Broadoak Farm, Linthwaite

ROAD SAFETY AUDIT - DESIGNERS RESPONSE

AJP Ref: 219-174

The report has been produced in response to the Stage 1/2 Road Safety Audit produced by Highways Associates (REF 2022/AJP/1590) to comment on the items raised in respect of the future use and safety of the proposed highways at the development of Broadoak Farm, Linthwaite.

TITLE: OUTLINE DRAINAGE LAYOUT

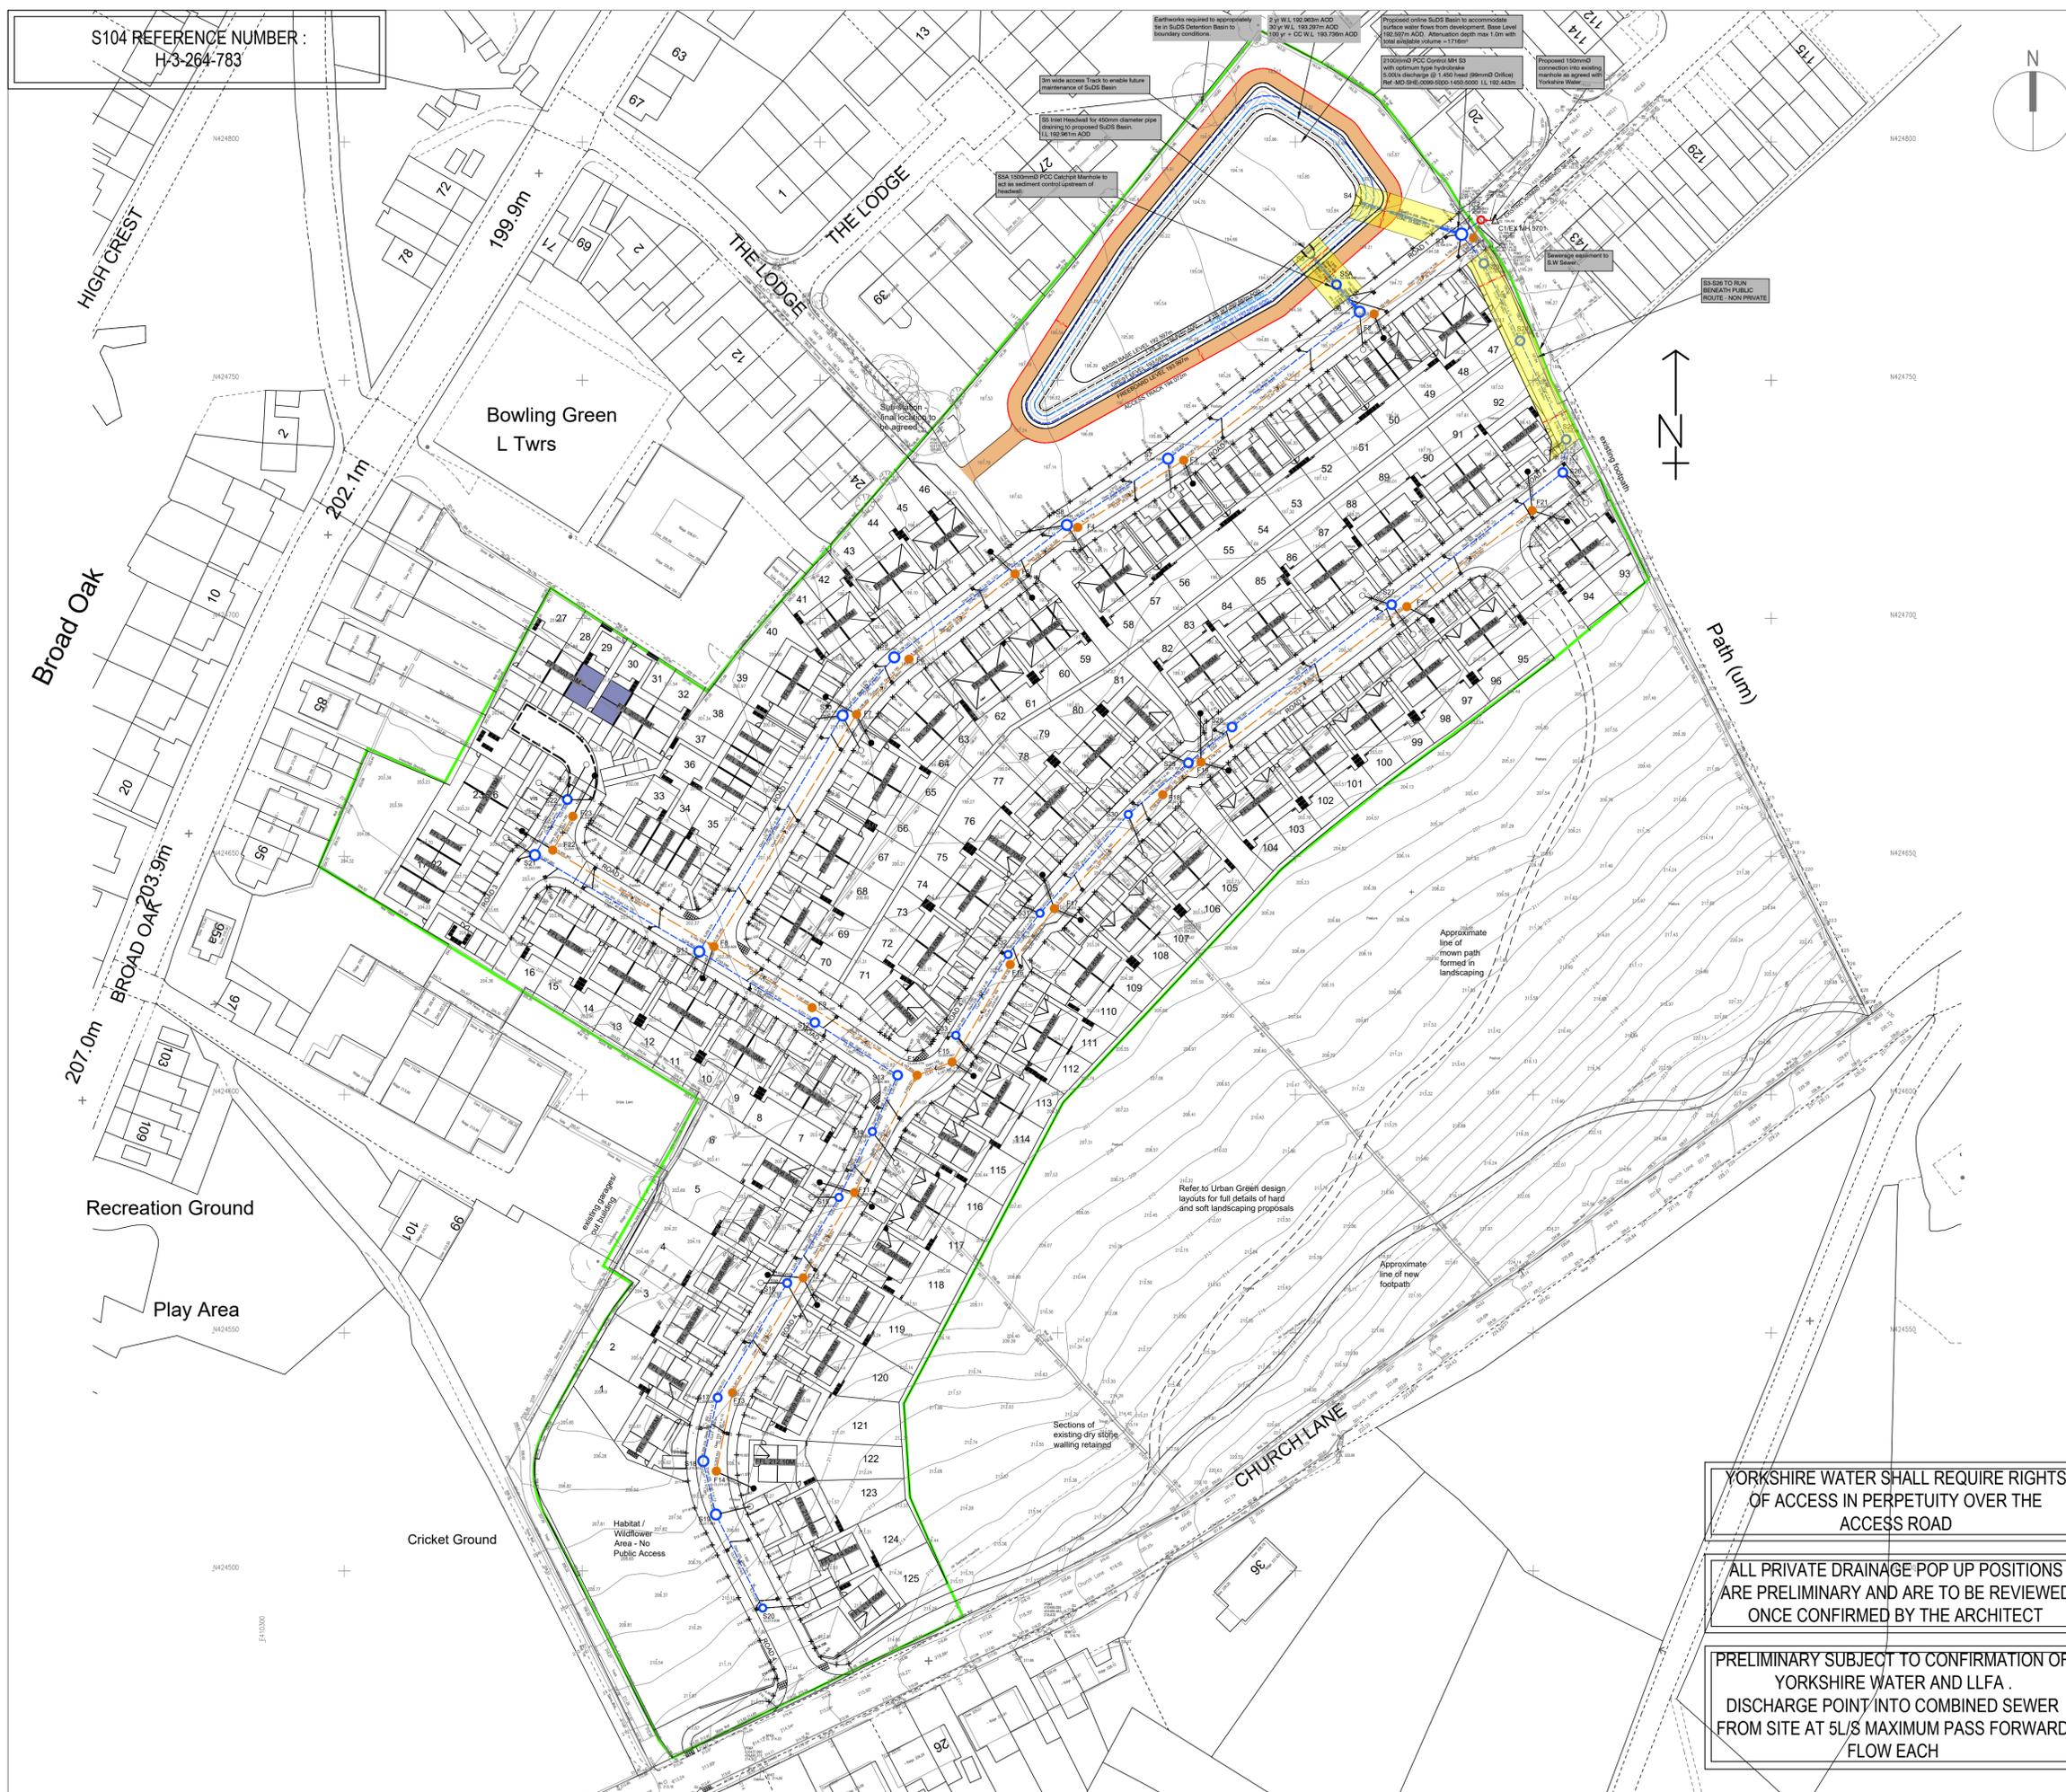
**LOCATION:** LOCATION: Plots 10, 16, 41, 42, 60, 68, 73, 75, 77, 80, 81, 85, 88, 91, 95, 96, 100, 102, 105, 107, 109, 111, 121

**SUMMARY:** Drainage gully locations could cause loss of control

Drainage gulleys appear to be located within the channels adjacent to the proposed vehicular crossings. Due to the inherent lack of skid resistance afforded by cast iron gulleys particularly when wet, concern is expressed that should they be struck particularly by powered or unpowered two wheelers whilst turning into the private driveway that it could increase the risk of loss of control.

The gulleys should be relocated to a suitable position along the kerb line outside of any dropped kerb areas.

Gullies have been positioned at low points and to accommodate the highway surface water flows. Where it's not possible to locate gullies outside vehicular crossings, they have been positioned outside the likely wheel tracking of vehicles accessing the proposed driveways.

TITLE: EXTERNAL WORKS PLAN (3 OF 4)

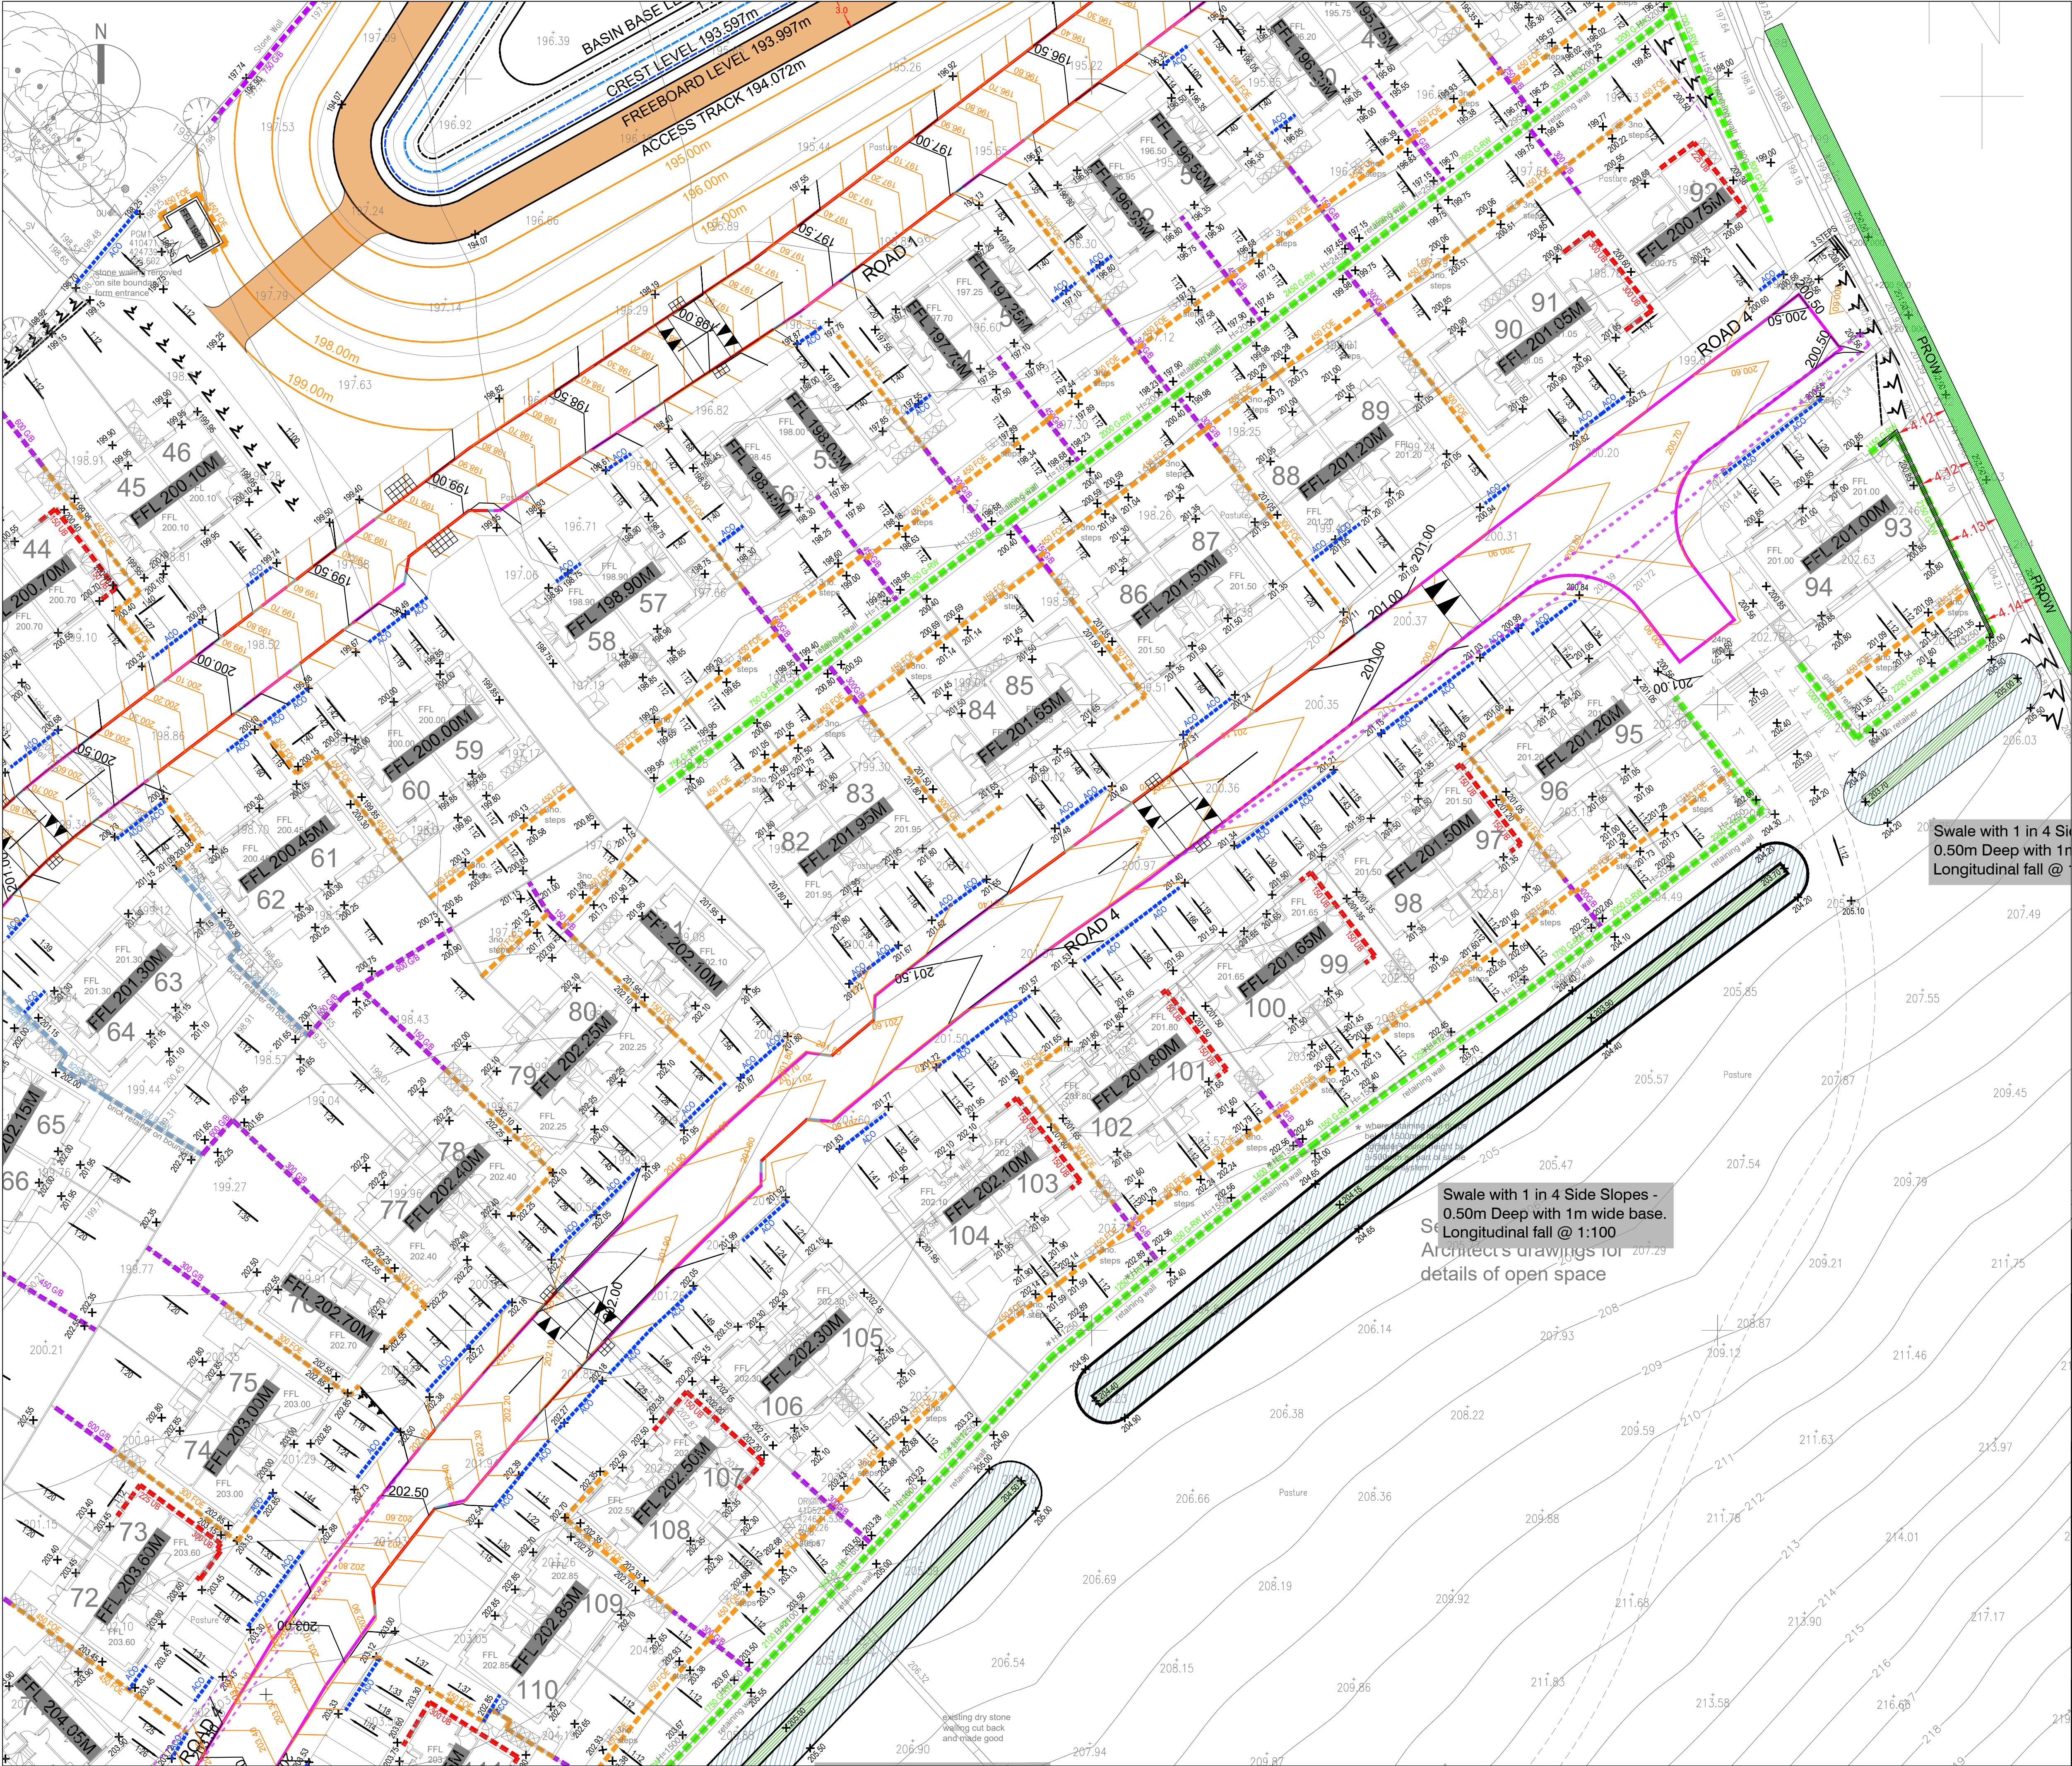
**LOCATION:** Roads 1 and 4

**SUMMARY:** Horizontal traffic calming measures not conspicuous

Concern is expressed that the proposed build-outs may not be suitable conspicuous particularly during poor weather events or dark conditions increasing the potential for the build-outs to be struck by passing traffic potentially resulting in loss of control or conflicts with passing

pedestrians established on the adjacent footways.

Suitable retroreflective bollards should be provided to demarcate the build-outs paying particular attention to obstruction of the footway or visibility for crossing pedestrian requirements.

Item accepted and reflective bollards noted as required on drawings.
